Rezoning Transportation Analysis

Petition Number: 2022-115

Date	Description
12-28-22	First Review (TM)
4-20-23	Second Review (TM)

RZ-1

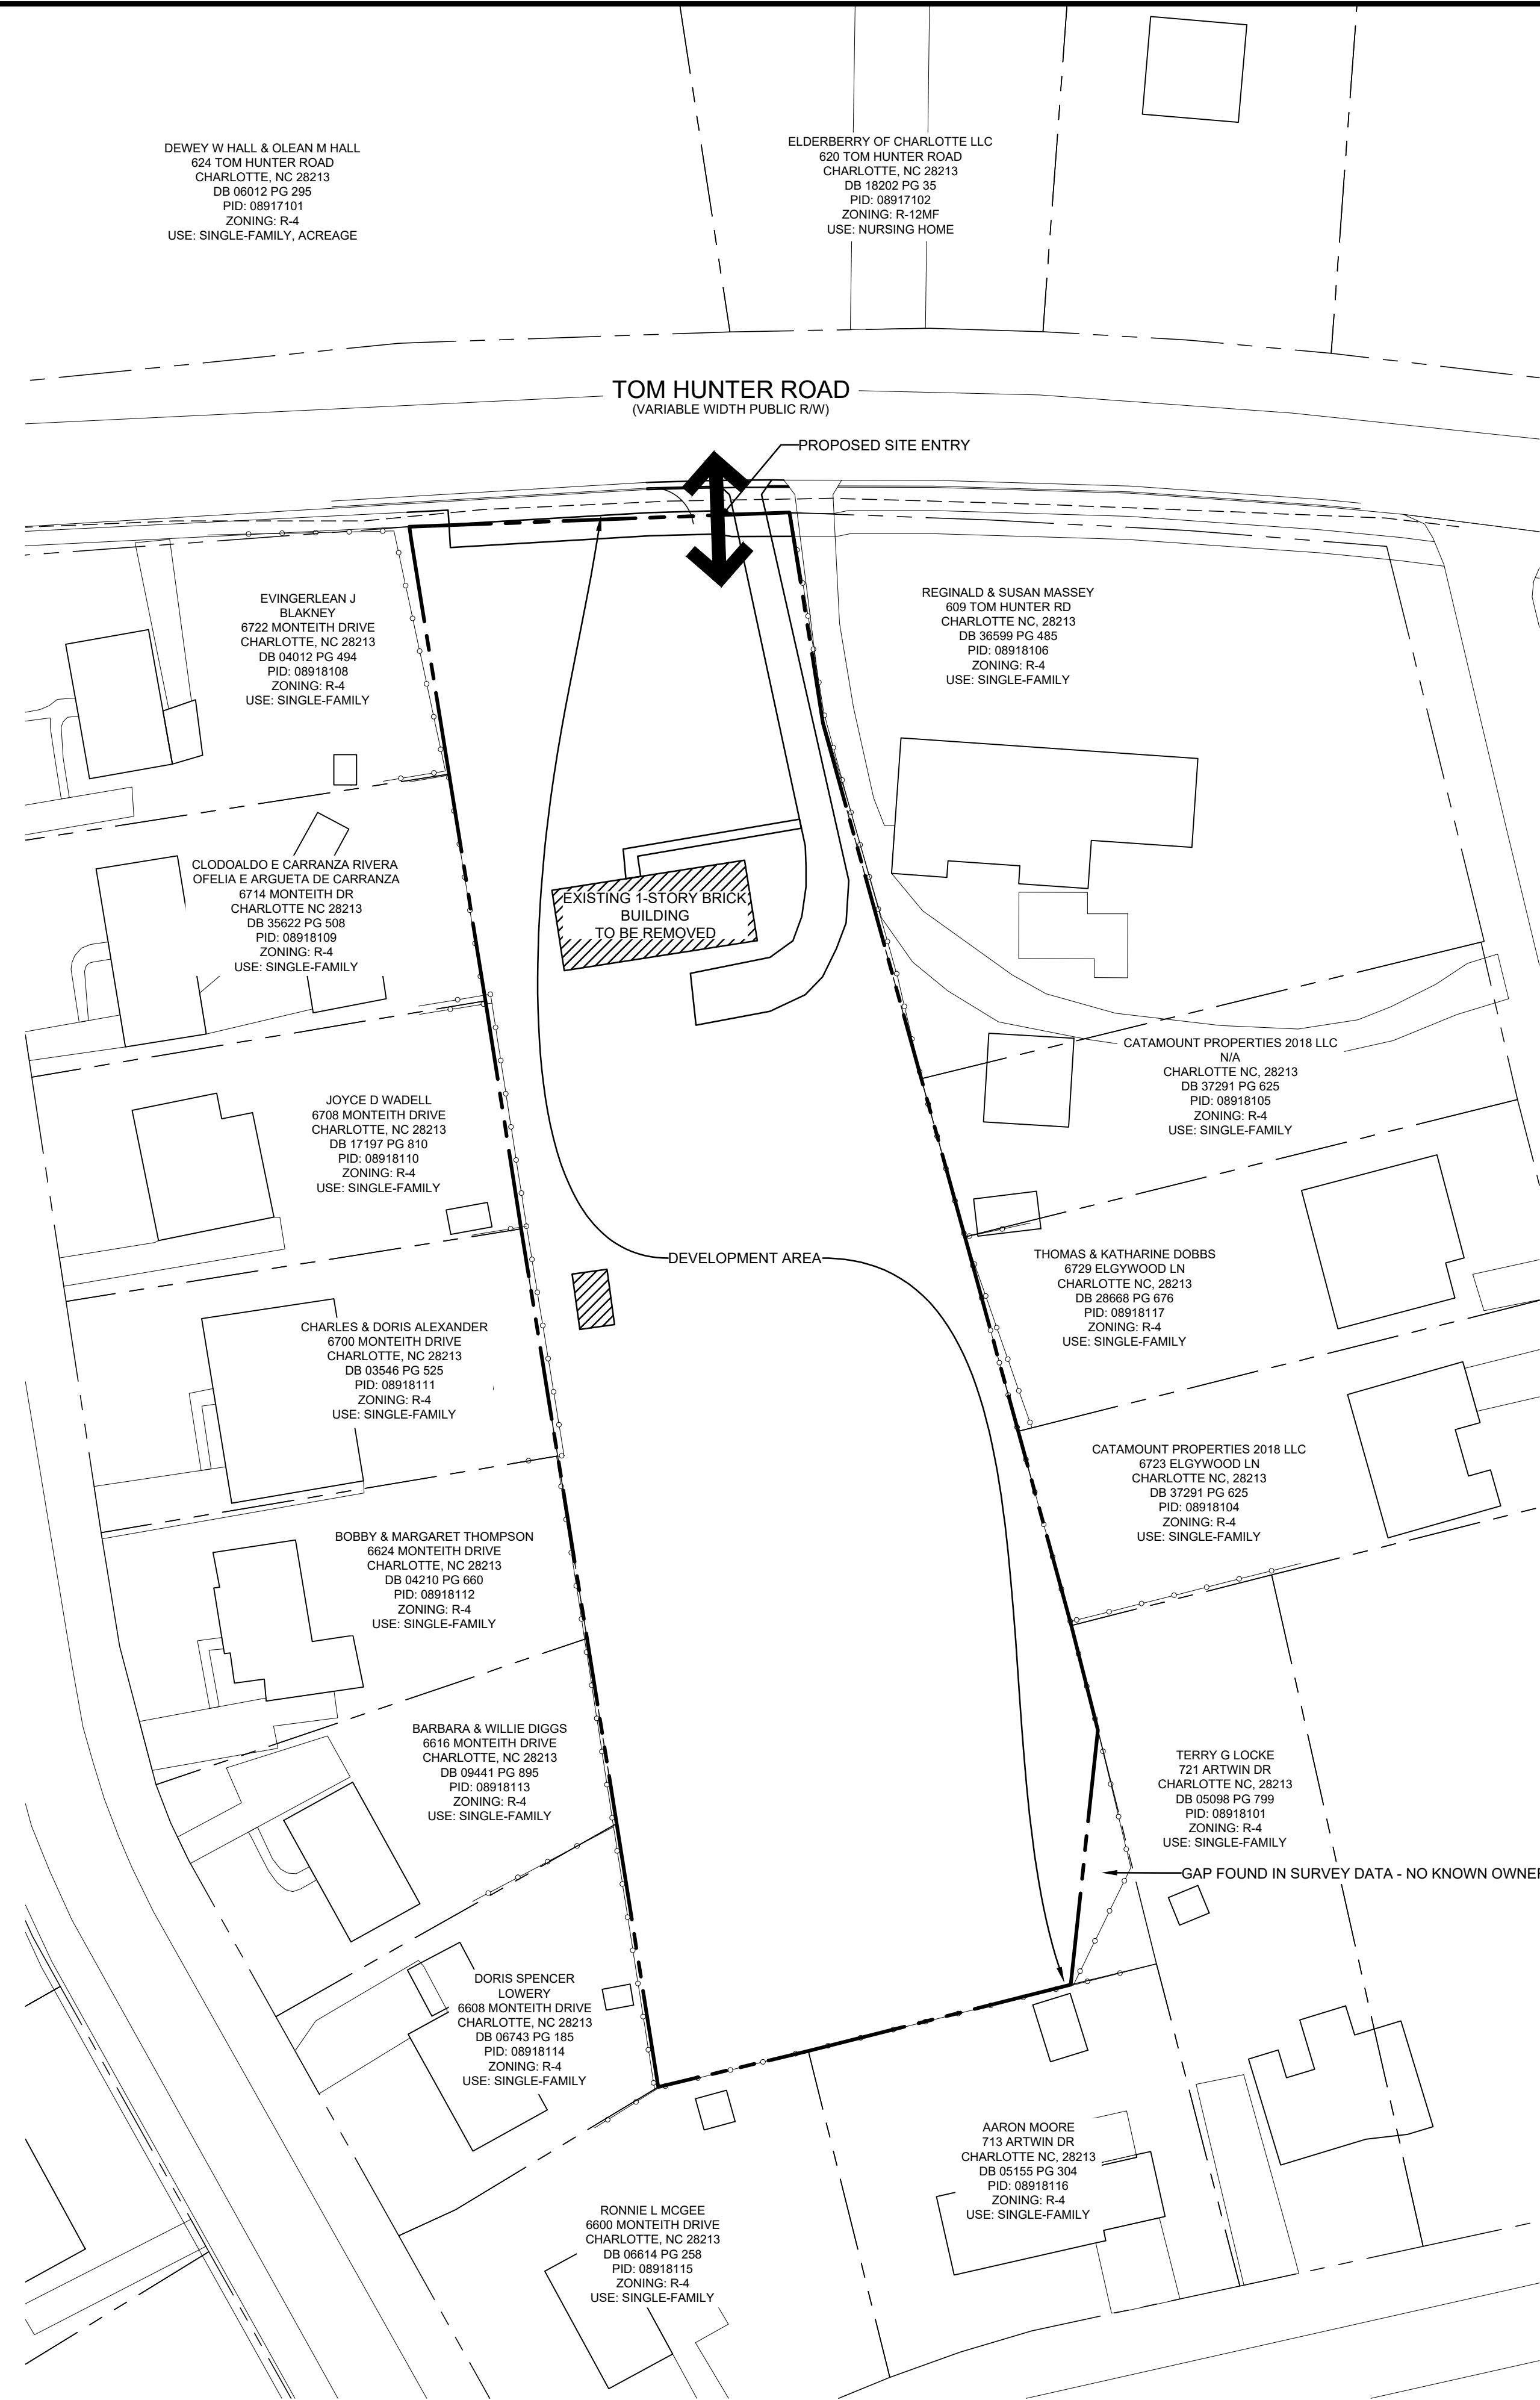
~~Comment Rescinded Clarifying Comment 04-20-23:~~ Show dimension of 24 feet from roadway centerline to back of curb and gutter in accommodation with Charlotte Streets Map and roadway typical section of CLDSM 11.09 Minor Thoroughfare.

3. New Comment from 4-20-23: Revise site plan to properly show access 10-feet from the property line. Dimension access from the property line to the radius point of the site access per City of Charlotte Driveway Regulations.

7. **Outstanding Comment From 12-28-22:** Add a conditional note specifying "A Right-of-Way Encroachment Agreement is required for the installation of any non-standard item(s) (irrigation systems, decorative concrete pavement, brick pavers, etc.) within a proposed/existing City-maintained street right-of-way by a private individual, group, business, or homeowner's/business association. An encroachment agreement must be approved by CDOT prior to construction/installation. Contact CDOT for additional information concerning cost, submittal, and liability insurance coverage requirements."
